From: [Dan Young](#)
To: [Chace Pedersen](#)
Subject: RE: LP-24-00002 Nelson View - Notice of Application
Date: Wednesday, April 10, 2024 9:09:22 AM

Subject: LP-24-00002 Nelson View - Notice of Application

CDS is requesting comment on the following 5-lot long plat application: LP-24-00002 Nelson View. Links to the file materials can be found below. The comment period will end **April 24, 2024, at 5pm**. CDS will assume your agency does not wish to provide comment if not received by this date. Please let me know if you have any issues accessing the materials.

NELSON VIEW PLAT PREPARED FOR NELSON VIEW LLC A PORTION OF THE SOUTHEAST QUARTER OF SECTION 20 TOWNSHIP 20 NORTH, RANGE 14 EAST, W.M. KITITITAS COUNTY WASHINGTON		
DWN BY	DATE	JOB NO.
DLP/GW/DBM	03/2024	230165
CHKD BY	SCALE	SHEET
DLP/DBM	1"=200'	2 OF 2

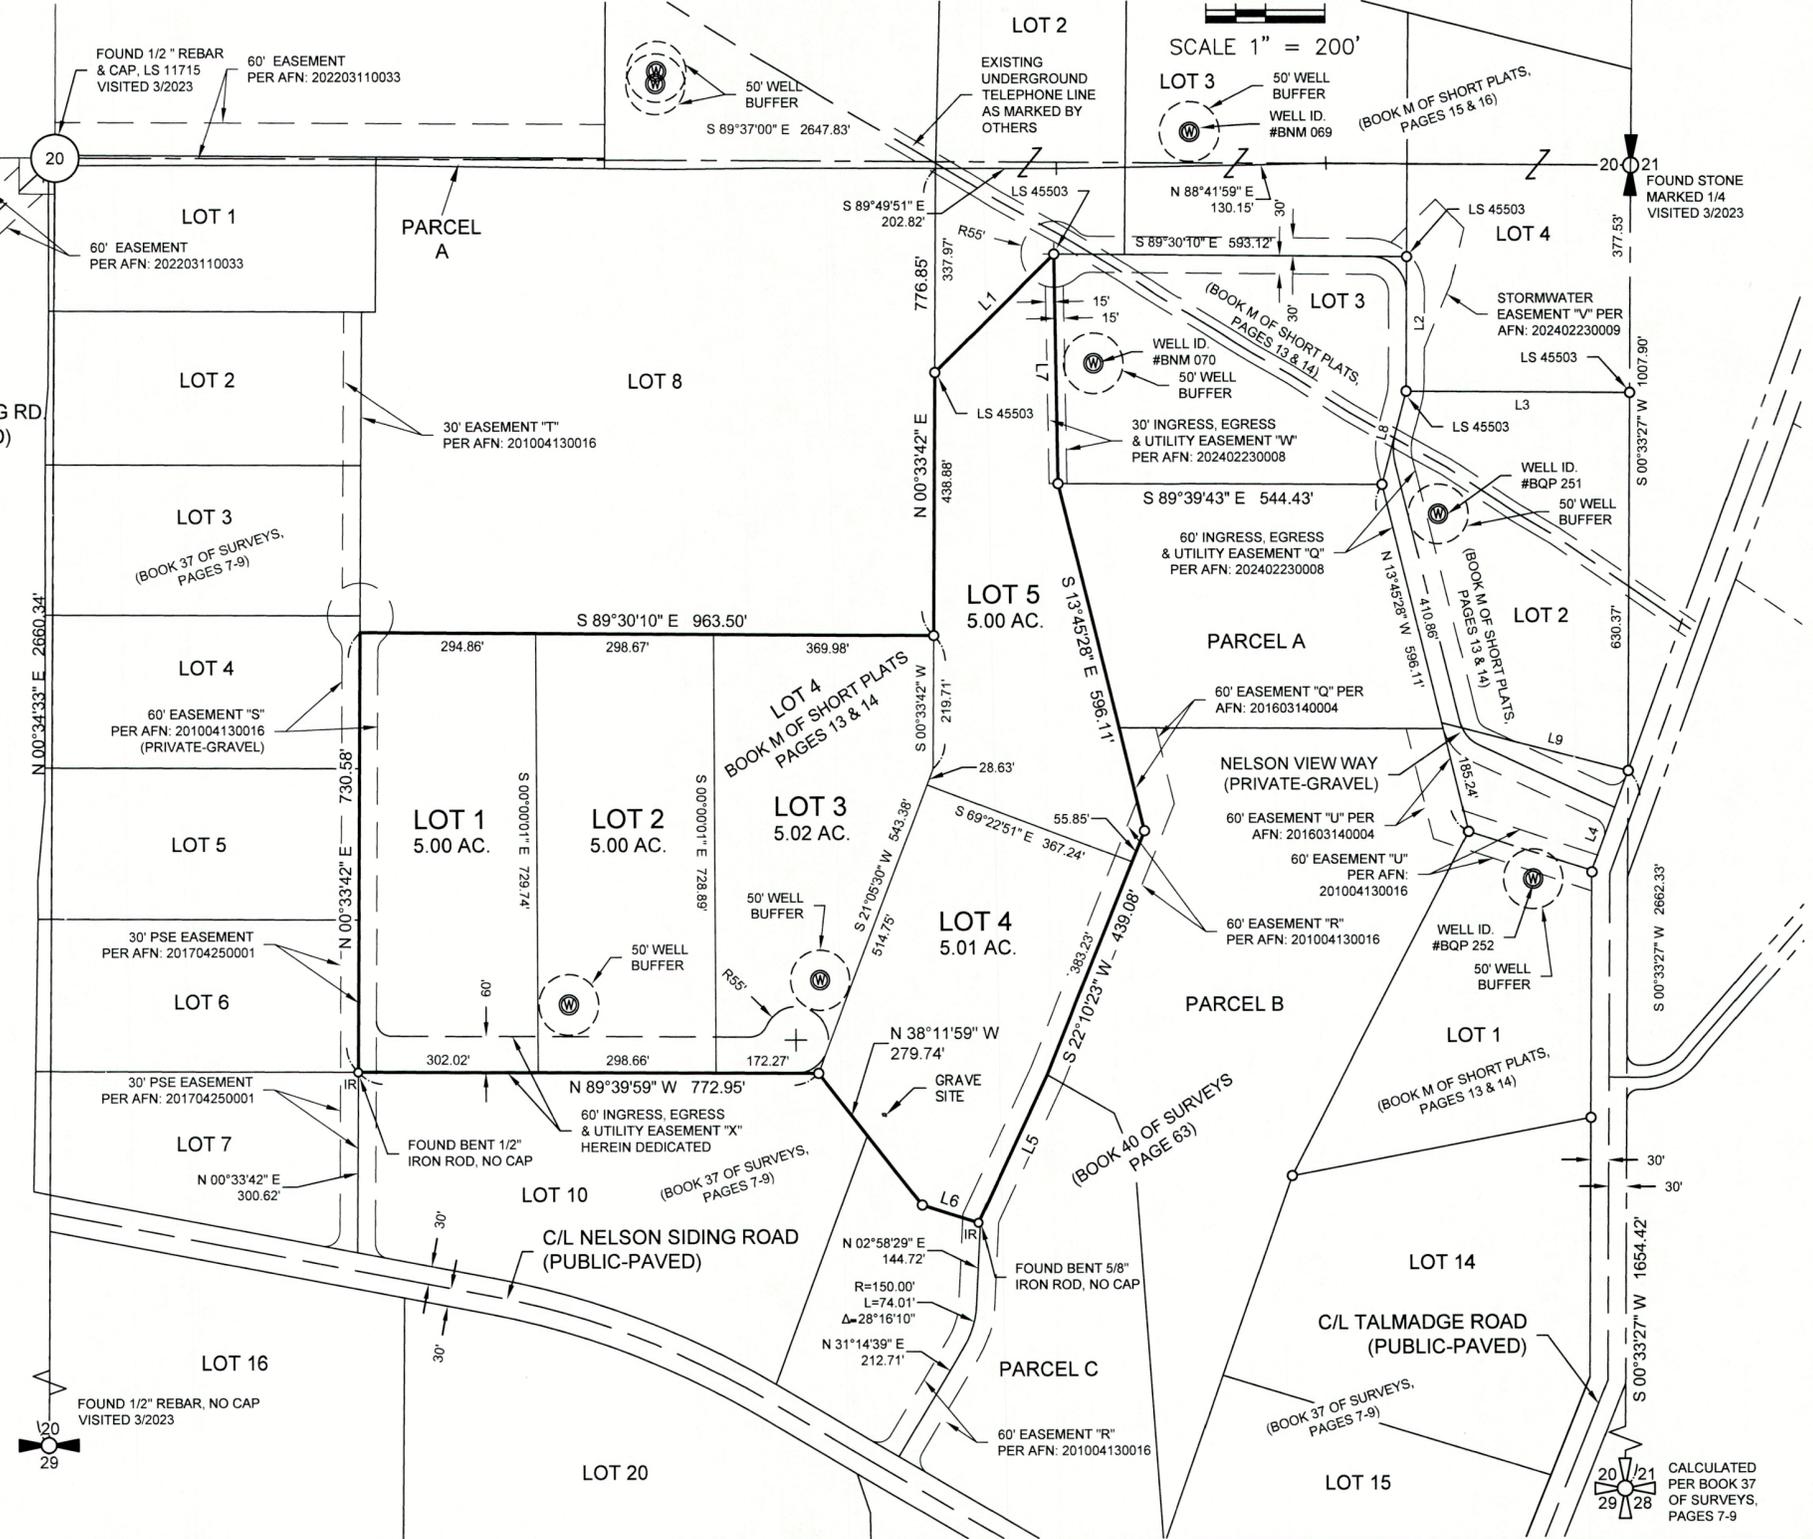
All roads must meet the requirements of the International Fire Codes including Appendix D .
If a gate is to be installed it must have a permit from the Fire Marshal's office.
